December 17, 2012

Mr. Ron Peaslee
Public Safety Inspector II, Plans Review
State Fire Marshal's Office
52 State House Station
Augusta, ME 04333-0052

RE: Building Permit Application – Portland Community Health Clinic Renovations,
180 Park Avenue, Portland, Maine

Partition Types

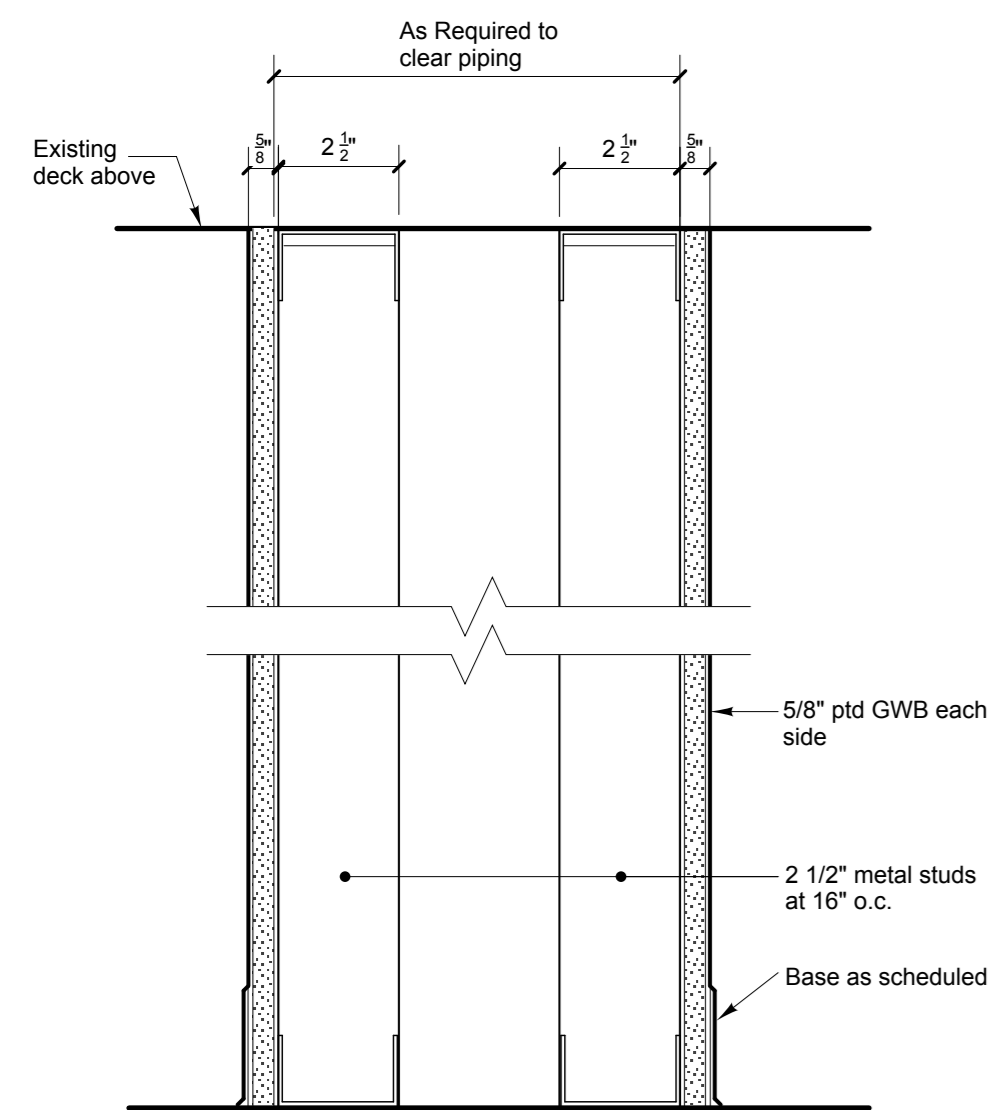
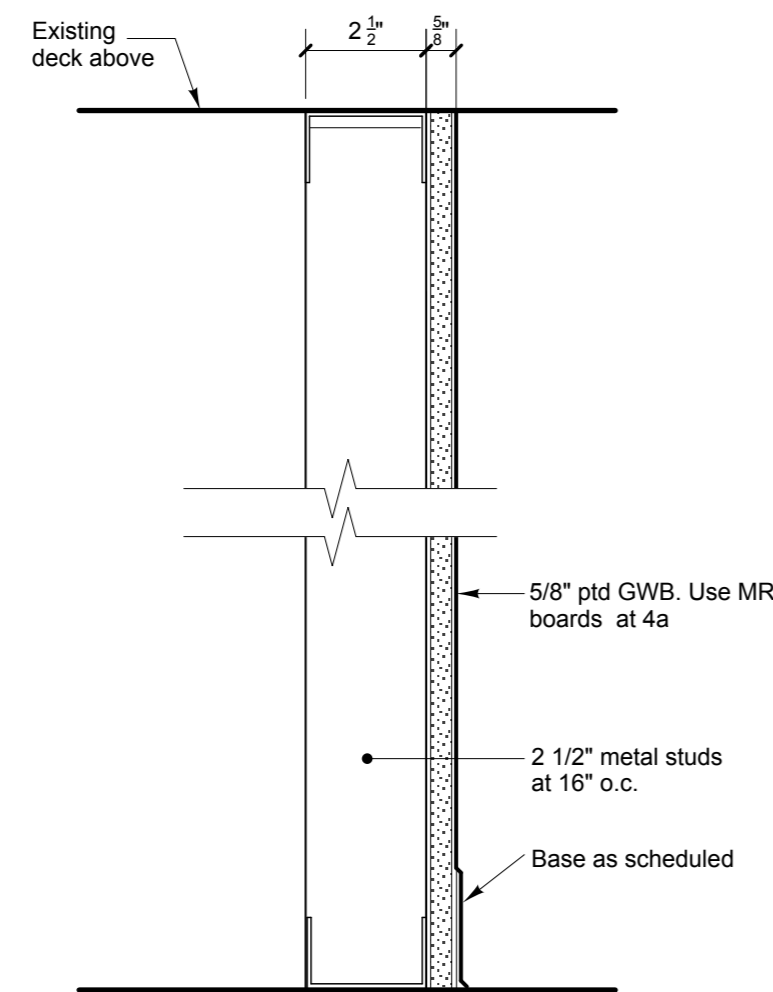
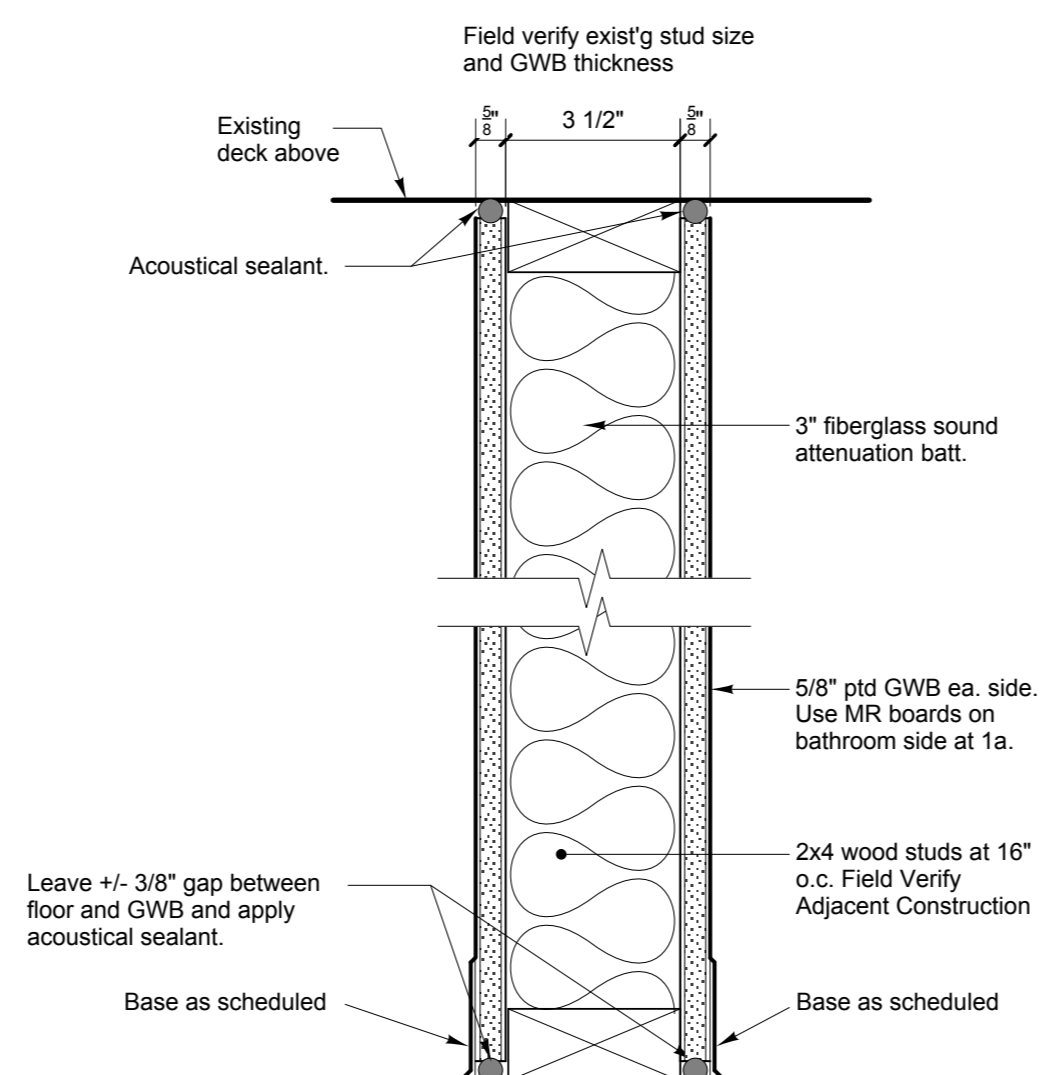
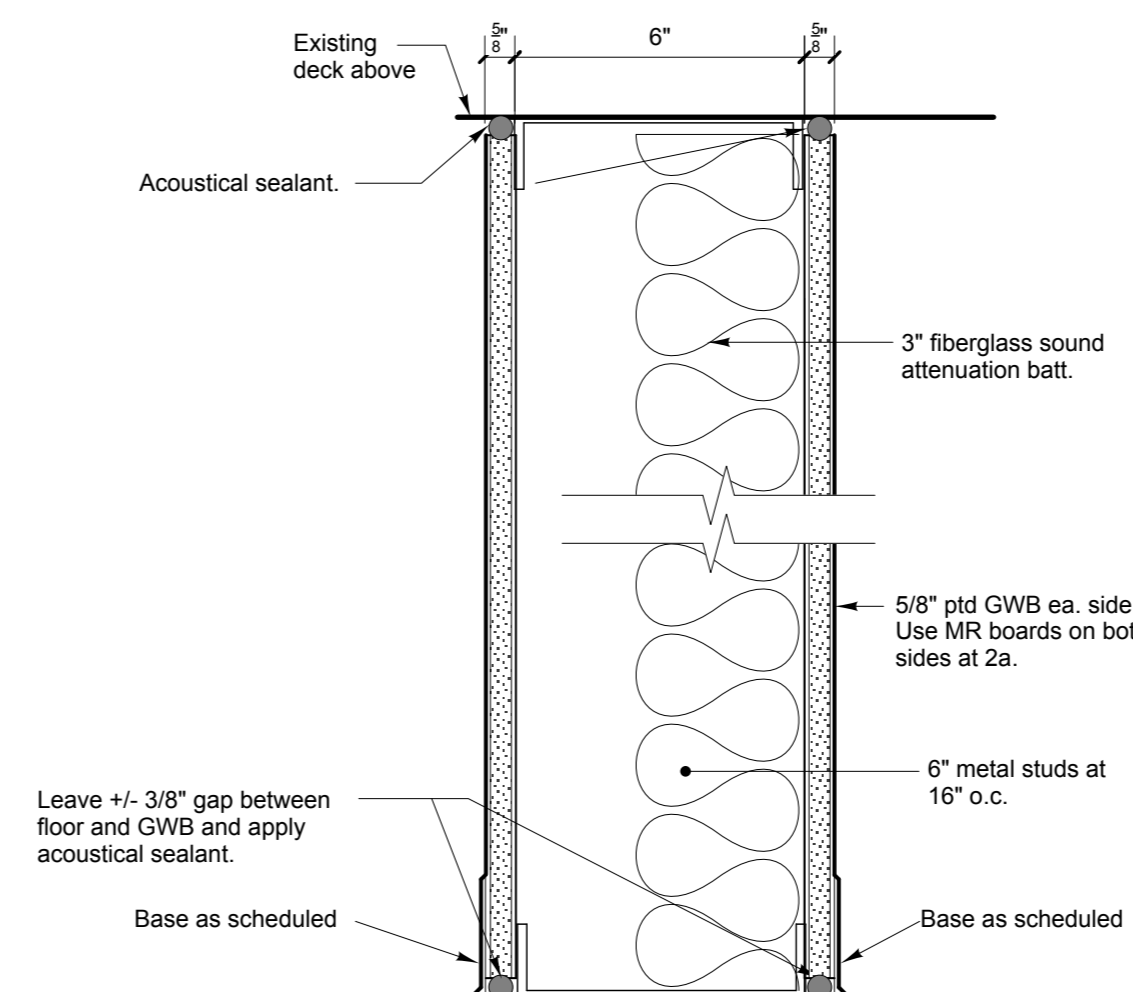
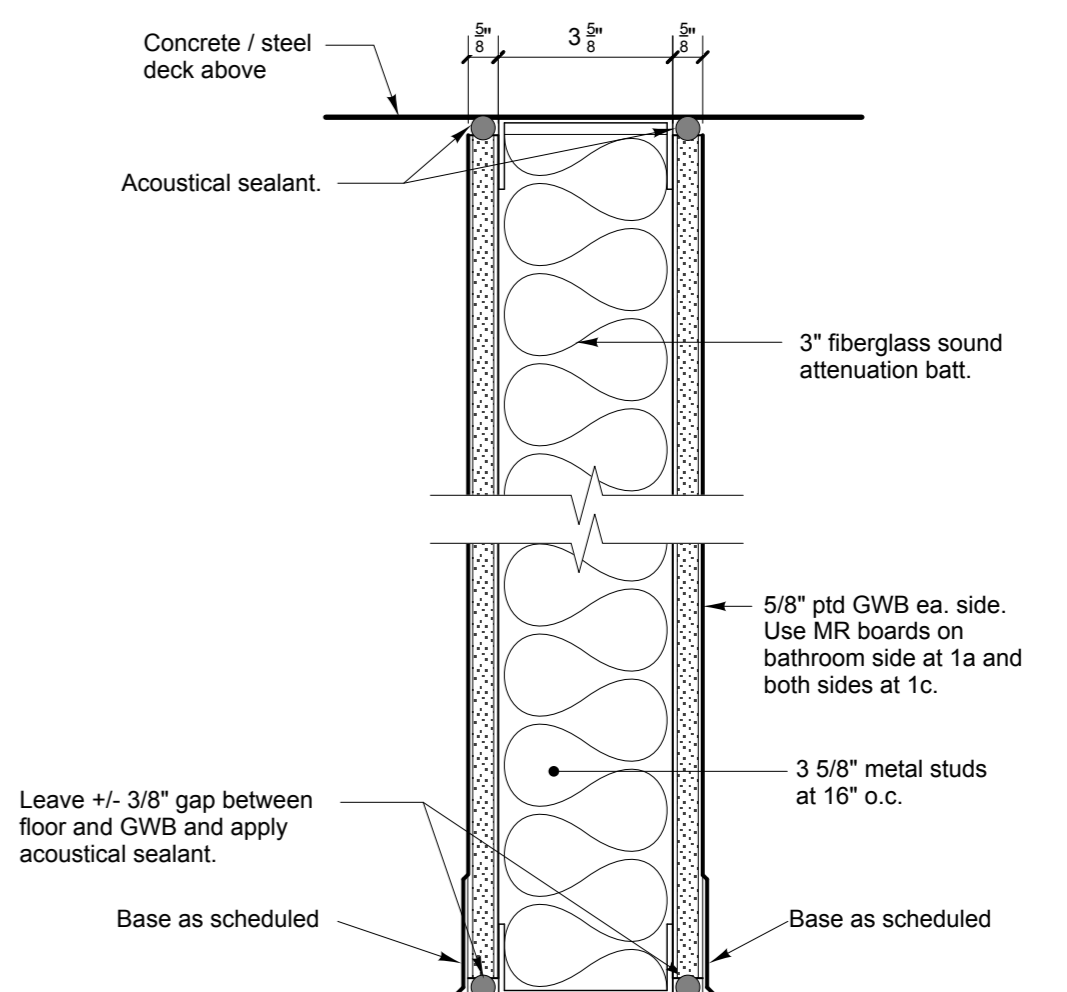
I'm following up on our telephone conversation today regarding the above referenced project. Per your previous review comments we are required to provide a 1 hour rating on corridor walls and ceilings with 20 minute rated doors w/ closers for the corridors within the tenant space. This requirement is described in NFPA chapter 38, article 38.3.6 which requires rated corridors unless the building is sprinklered.

It is my understanding that it is the position of the Fire Marshal's office that exception 2 under this article stating that rated corridors are not required within a single tenant space does not apply in this instance because the space exists within a multi story, multi tenant building that shares a rated exit stair and therefore it cannot be classified as a single tenant space.

Attached you will find a sketch showing the affected walls, ceilings and doors to be rated.
